**Consultation Response from KC,
Strategic Housing**

2026/90310 land off, Sunny View, White Lee, Batley, WF17 8FP

Erection of 37 dwellings with associated access, parking, landscaping and creation of multifunctional area of public open space

Responding Ref: SH/26/90310

Proposed Site Layout

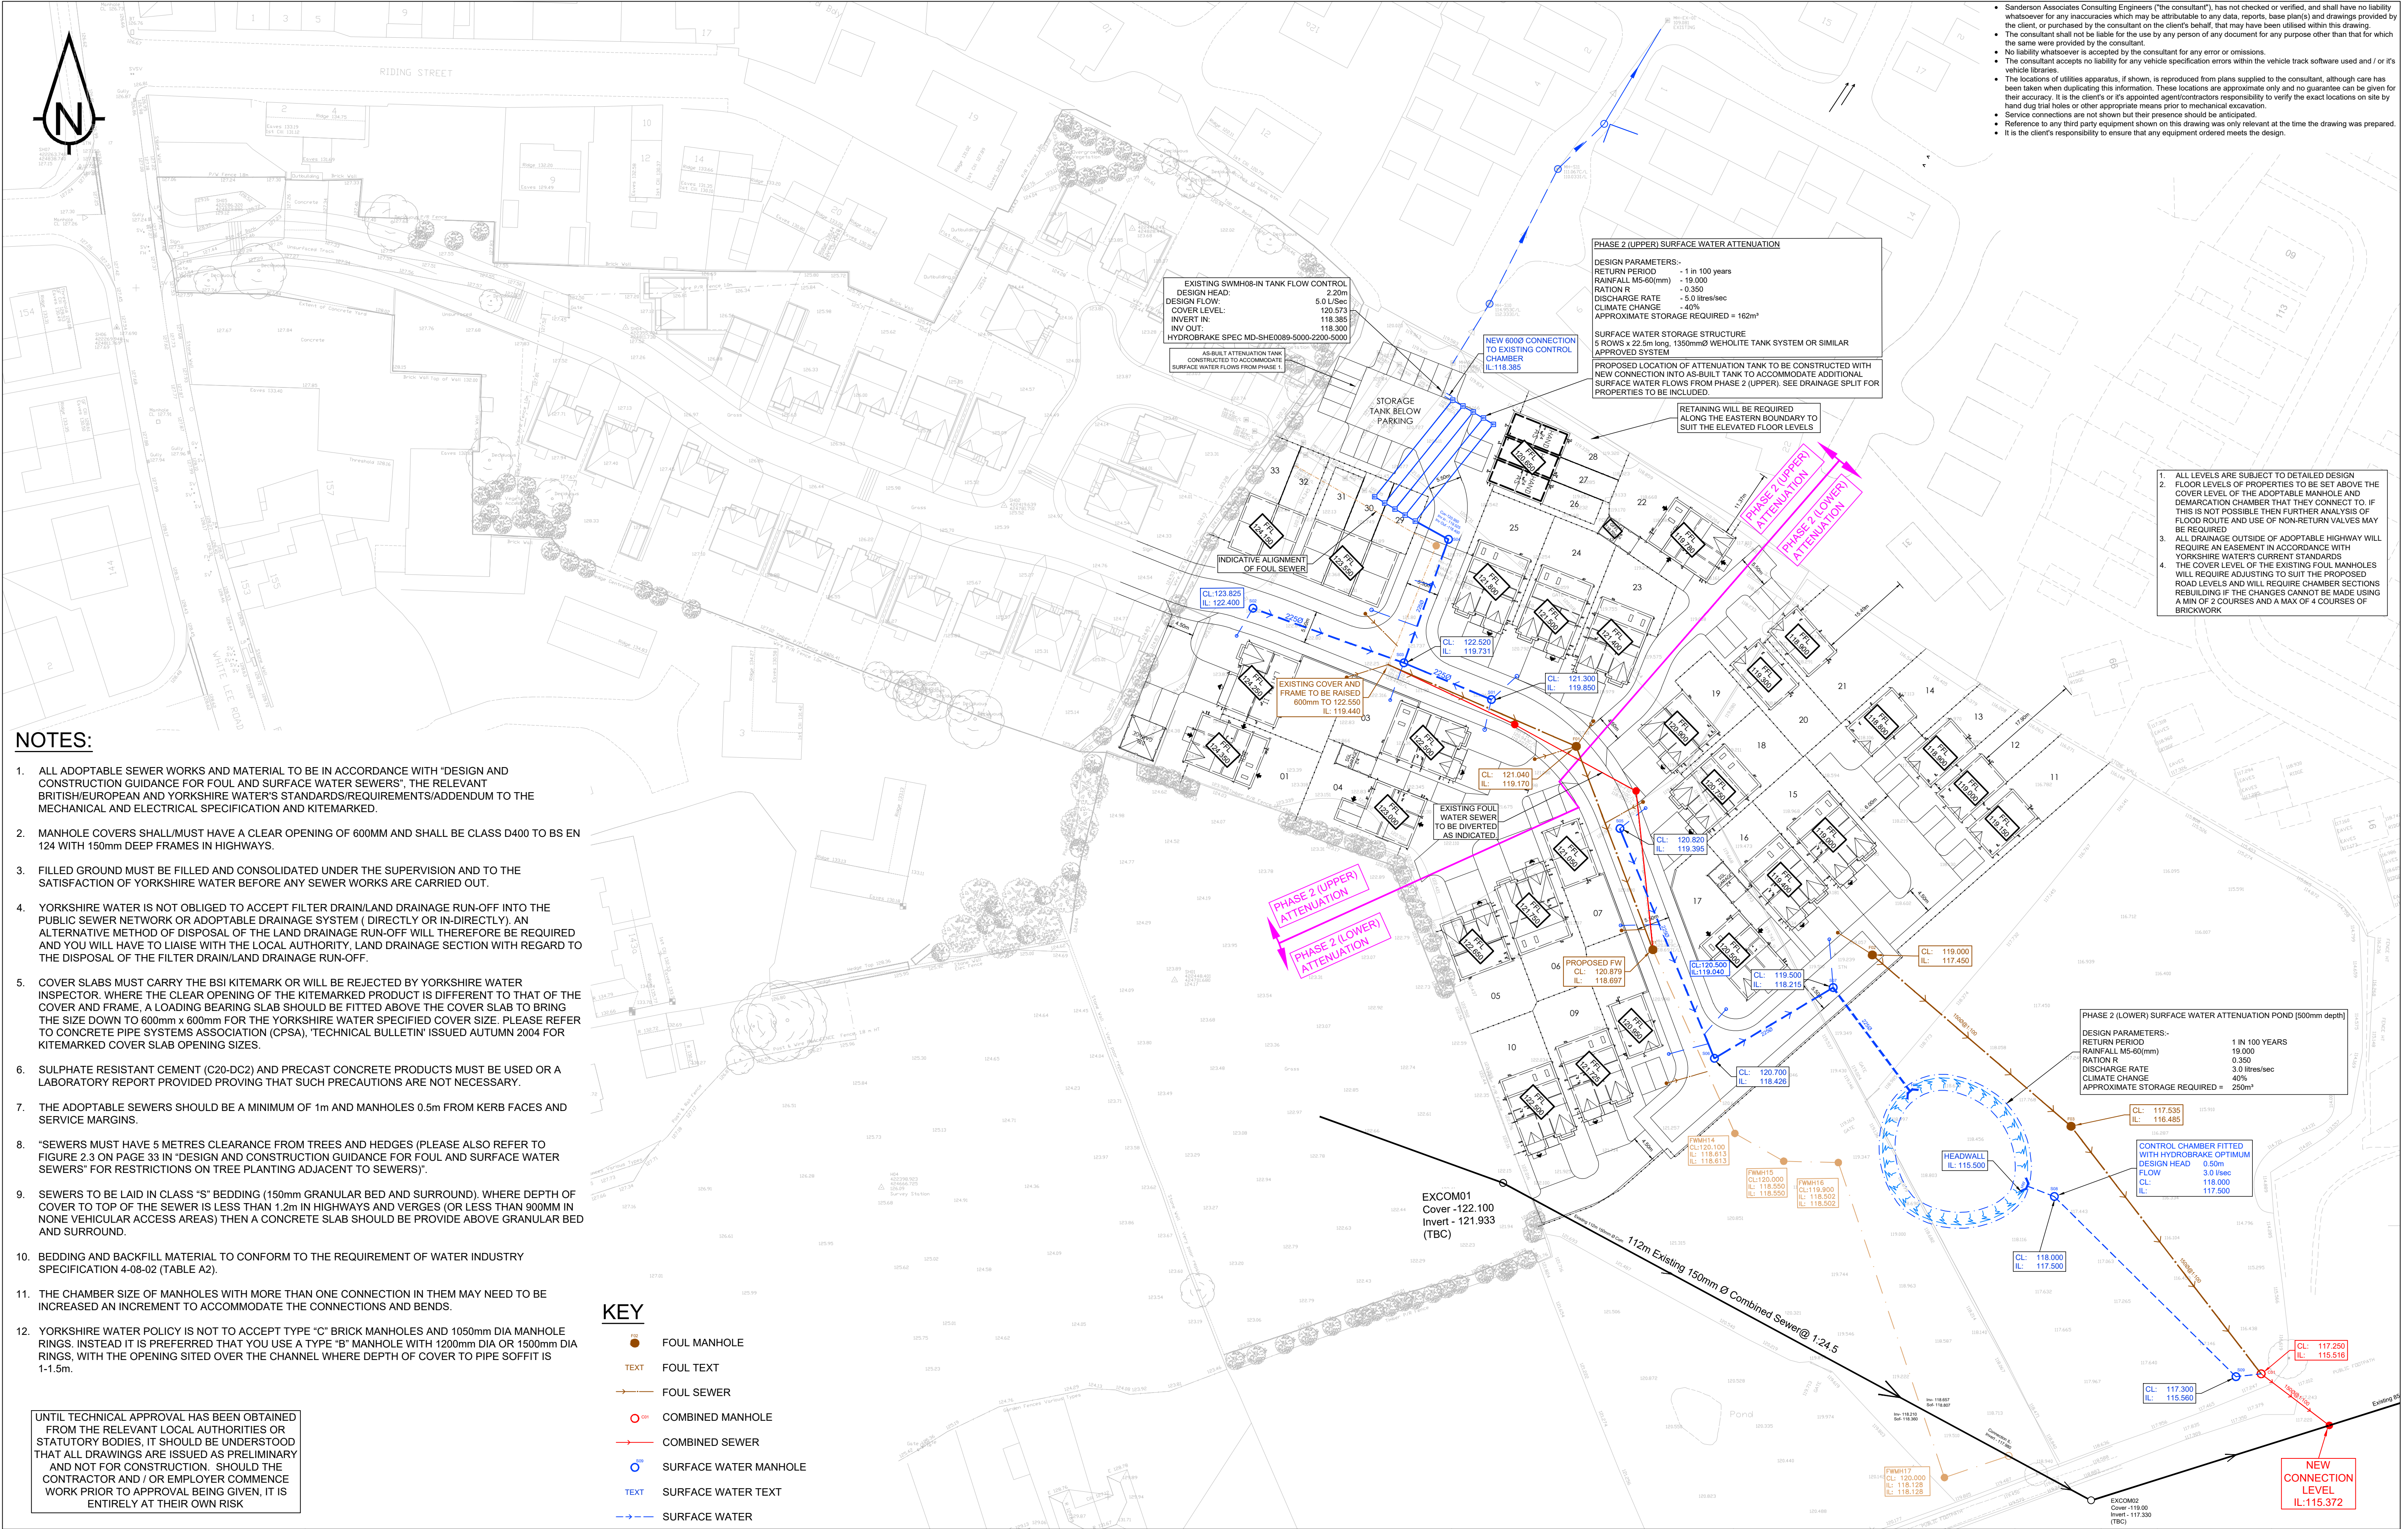
Strategic Housing request that the housing mix is amended to comply with the Housing Mix table for Batley and Spen set out above and in the SPD. To support an indistinguishable spread of market and affordable housing, it is requested that consideration to providing a 4 bed affordable dwelling is included. The proposed mix for Affordable Intermediate is requested to offer 1 and 2 bed properties as identified in the SPD.

The layout of affordable dwellings should be dispersed throughout the site in smaller clusters, avoiding large groupings of affordable dwellings together that may reinforce social exclusion. Affordable dwellings should be well integrated within the site layout and not located at specific areas at the edges of sites.
